Application for a Non-Material Amendment Following a Grant of Planning Permission

Single storey rear extension

23/00905/FULHH

Design of the flat roof above the approved rear extension to be amended to a parapet roof.

CLIENT	Hadi, Saif				
PROJECT	Proposed Extensions & Internal Alterations to 8 Tuson Lane, Whittle-le-Woods, Chorley, PR6 7FZ				
DRAWING	Proposed Ground Floor Plan, Roof Plan & Elevations				
DRAWN	EGR	DATE	14/02/24	NUMBER	23/086/P01
SCALE	1:100	SHEET	A2	REVISION	A

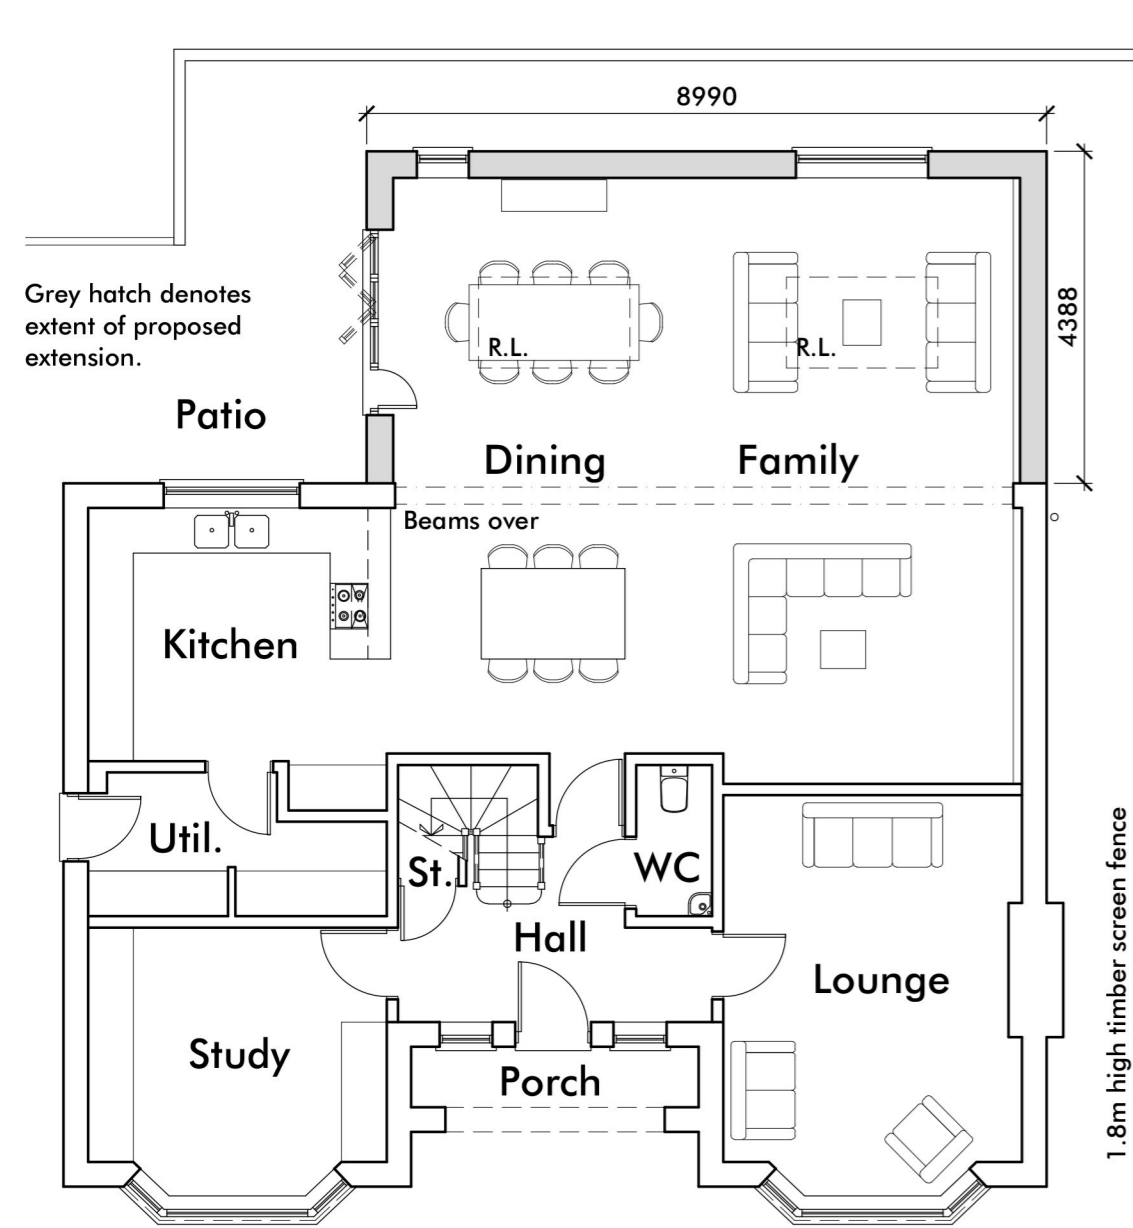
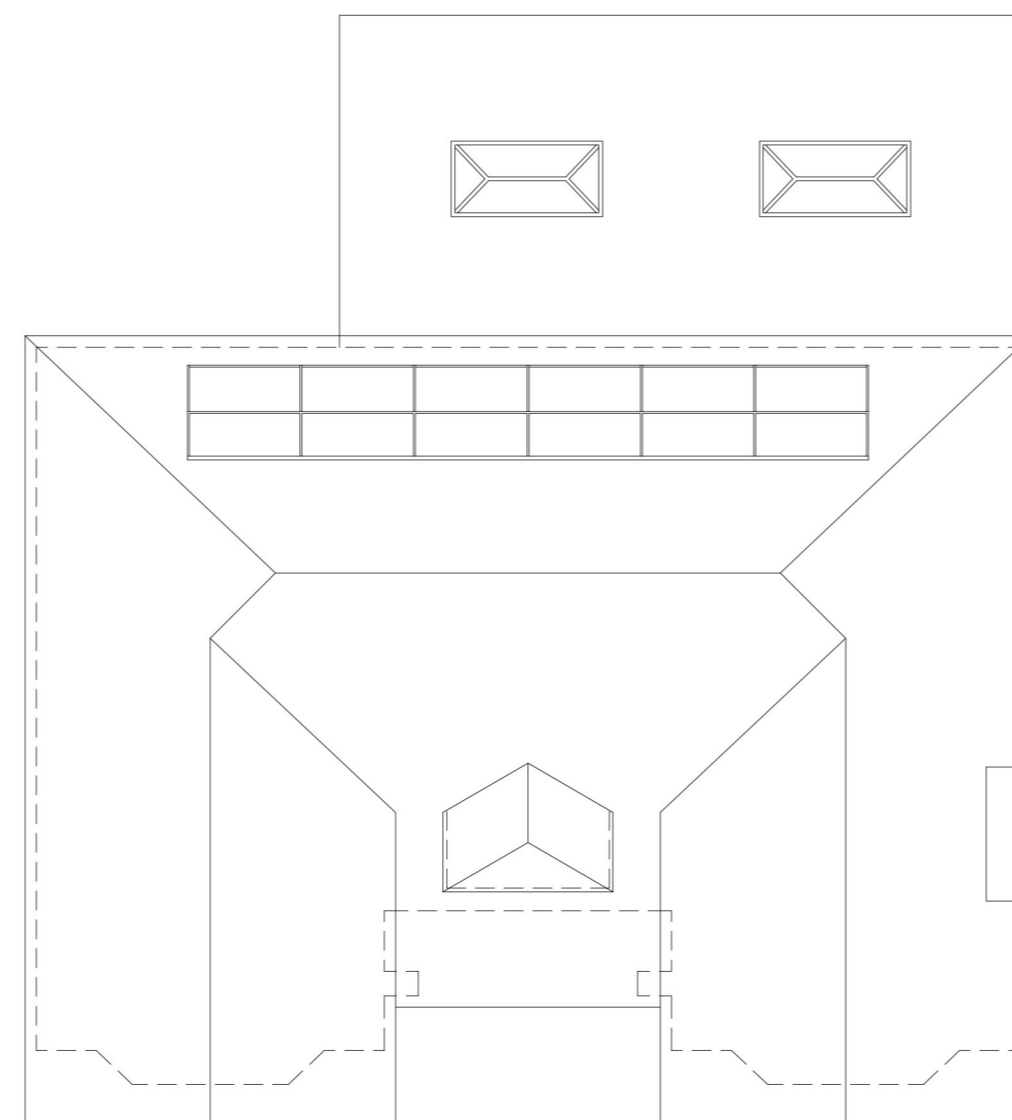
23/086/P01 - Proposed Ground Floor Plan, Roof Plan and Elevations

23/086/P01A - Proposed Ground Floor Plan, Roof Plan and Elevations
